## **945 & 1015 Bank Street**

Urban Design Review Panel Report – Revision 1  
Site Plan Control  
September 9, 2024

# 945 & 1015 Bank Street - Lansdowne 2.0 Event Centre

## Response to Informal UDRP Comments

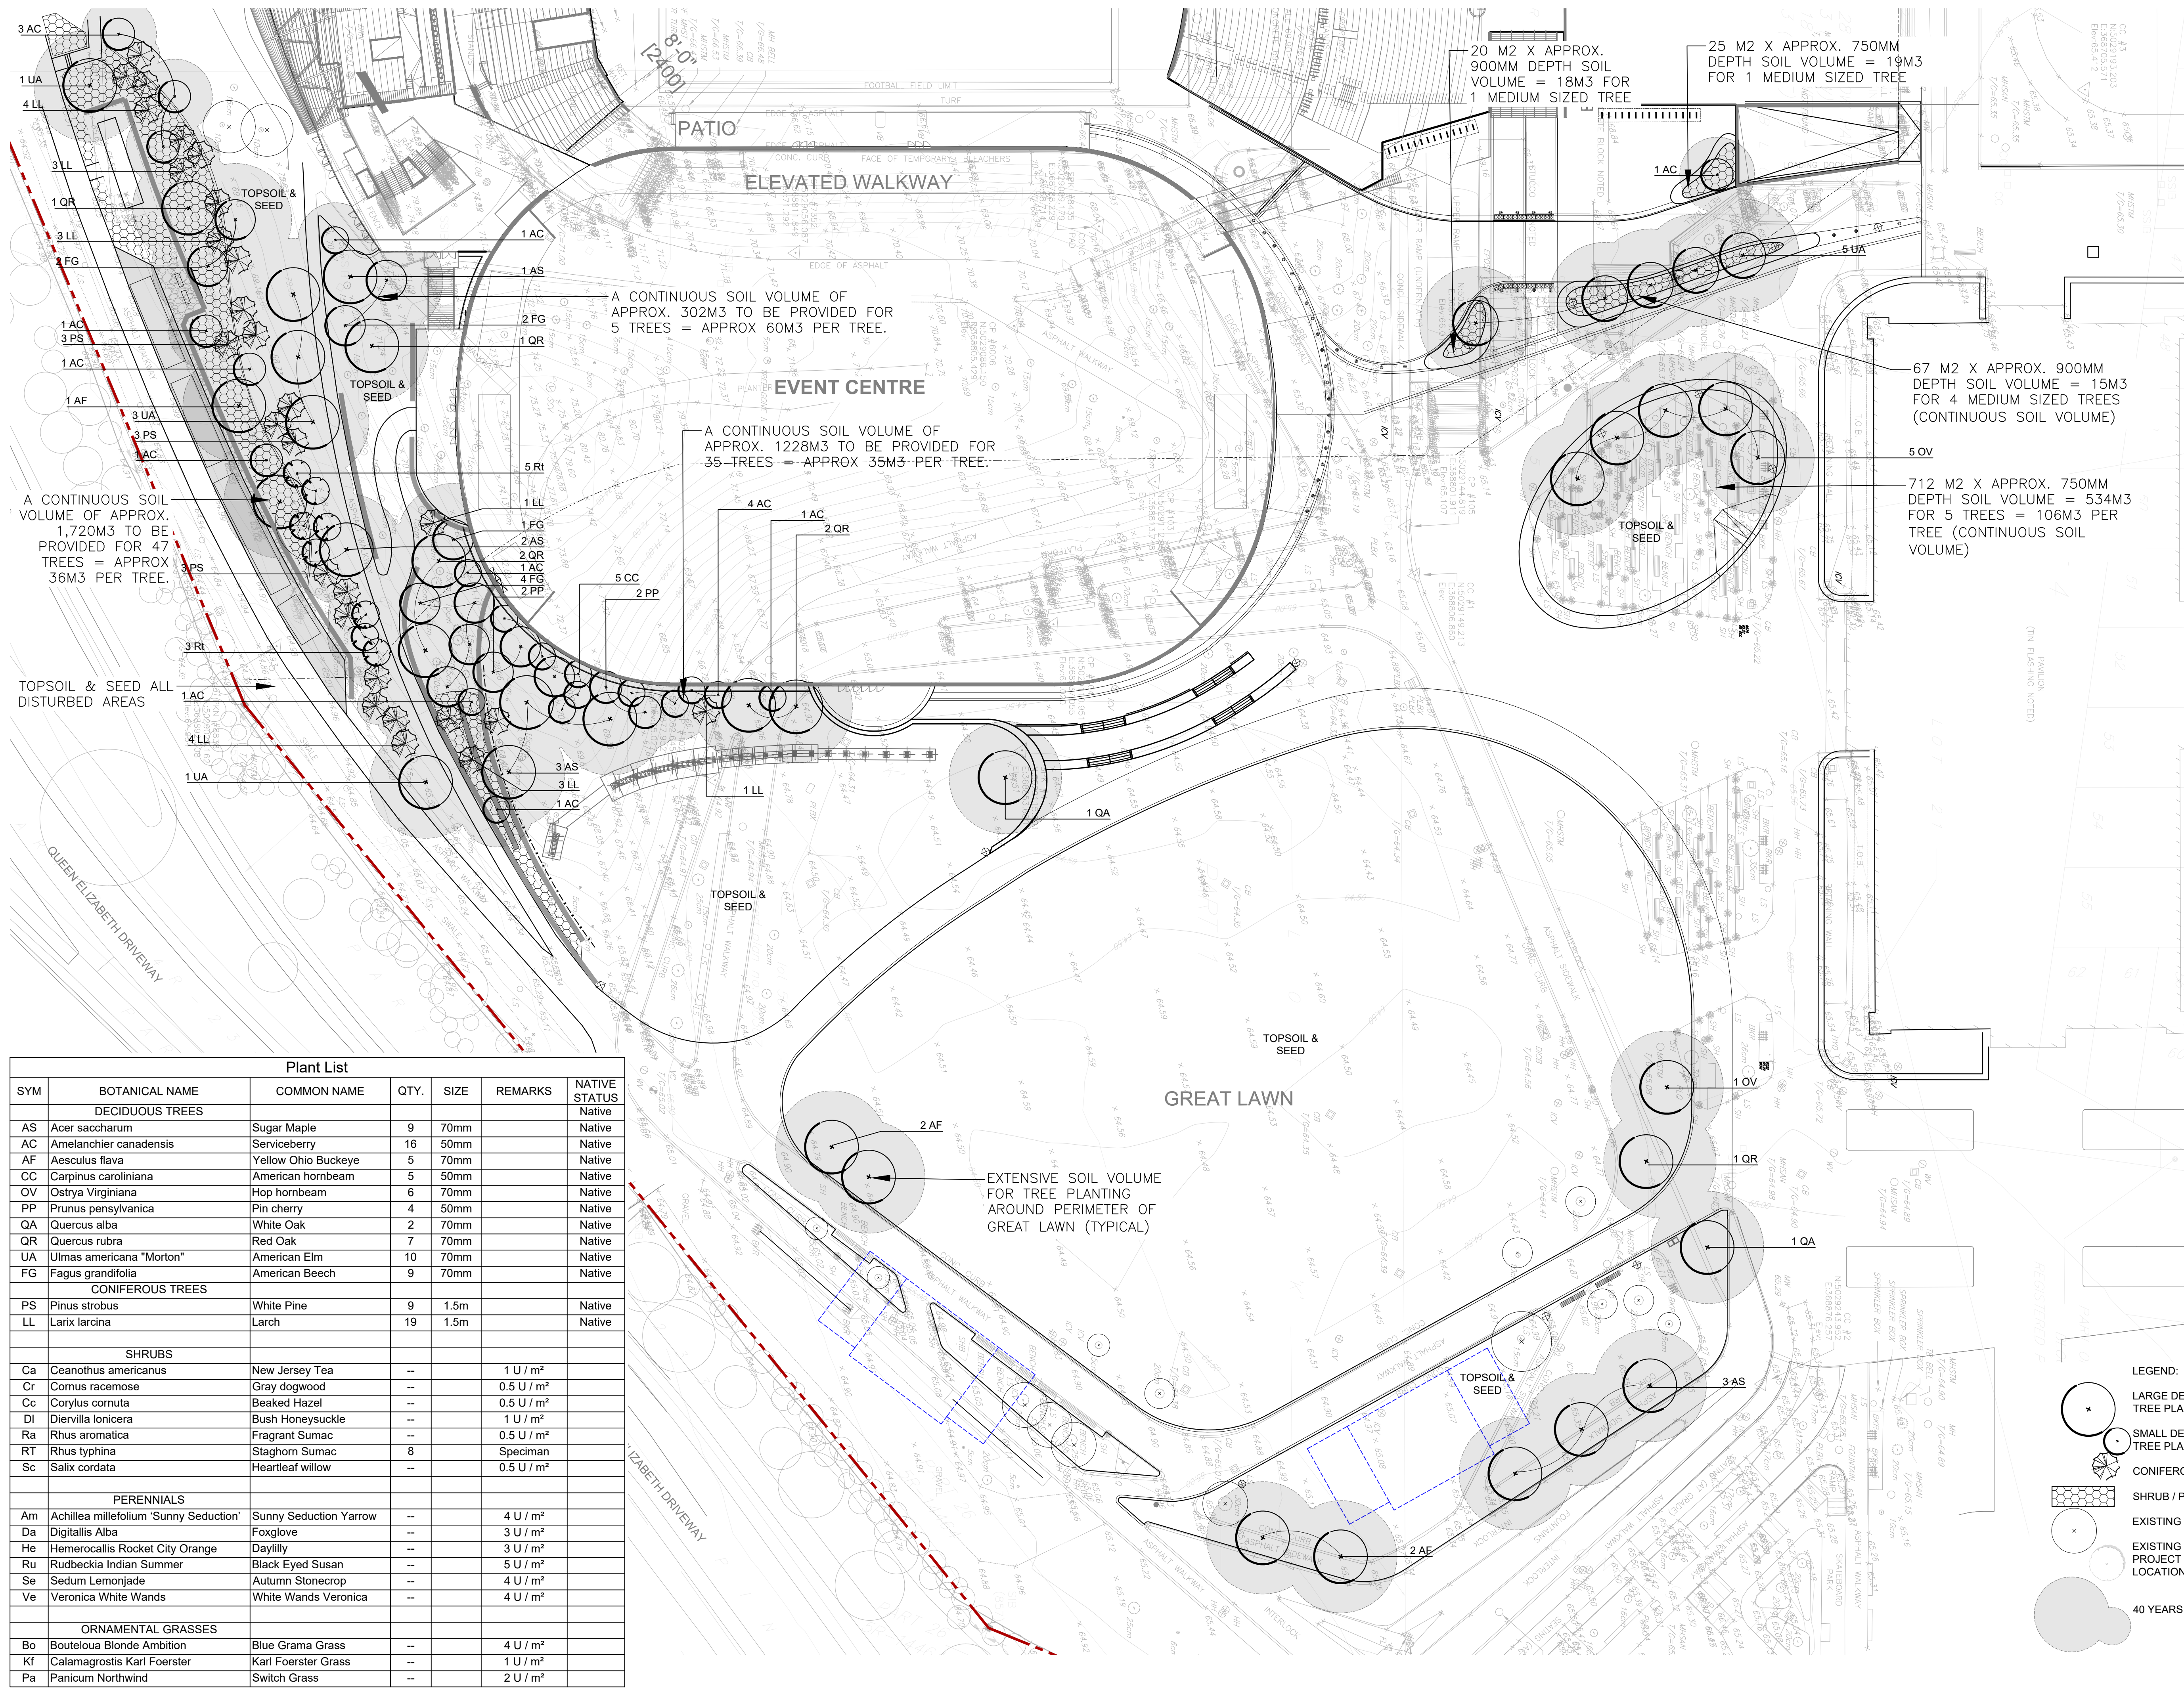
No.	Comment	Response
1.5	The Panel recommends exploring more of an orthogonal geometry to the north edge of the Event Centre that responds to the existing award-winning landscape design and surrounding orthogonal built form. The Panel equally recommends the landscape of the plaza gathering space between Aberdeen Pavilion and the proposed Event Centre be consistent with the existing orthogonal design language.	The Great Lawn and surrounding landscape provides a place of respite from the more active urban landscape of the broader Lansdowne Park. The softer geometry and flowing pathways complement the uses of the space, the shape of the berm and the geometry of the new Event Centre. It also accommodates the flow of large volumes of pedestrians during the many outdoor events held in this space and addresses the existing CPTED issues with the current installation. The current geometry also responds to the requirements of the site creating an open main entrance and entry plaza that flows into the Great Lawn.

2.3	The Panel recommends protecting and maintaining the existing landscaped border surrounding Aberdeen Pavilion on all sides, including at the southwest corner of Aberdeen Pavilion by the pinch-point, where the proposal seems to deviate from the existing landscape treatment. This landscaped edge of Aberdeen Pavilion is instrumental in framing the heritage building and embellishing its prominence on the Exhibition grounds.	Please see updated Landscape Plan.

No.	Comment	Response
2.4	The Panel has concerns with the landscaping walls proposed not being compatible with the existing landscape language, for which the site has previously received a CSLA Award of Excellence. The Panel recommends retaining as much of the existing landscape design/language as possible and ensuring compatibility with the award-winning landscape design wherever landscape improvements are necessary for the Event Centre.	<p>The landscape space between the new Event Centre and existing Aberdeen Pavillion can not be retained due to the proposed building elevation of the EC and the desire to provide a fully accessible landscape and visual connection between the new EC and existing Pavillion. Refer to response 1.4 above for further explanation of the design intent. The detailed design of the walls will be similar in design to the existing c.i.p concrete seating walls with wood top benches. See adjacent image for reference.</p>
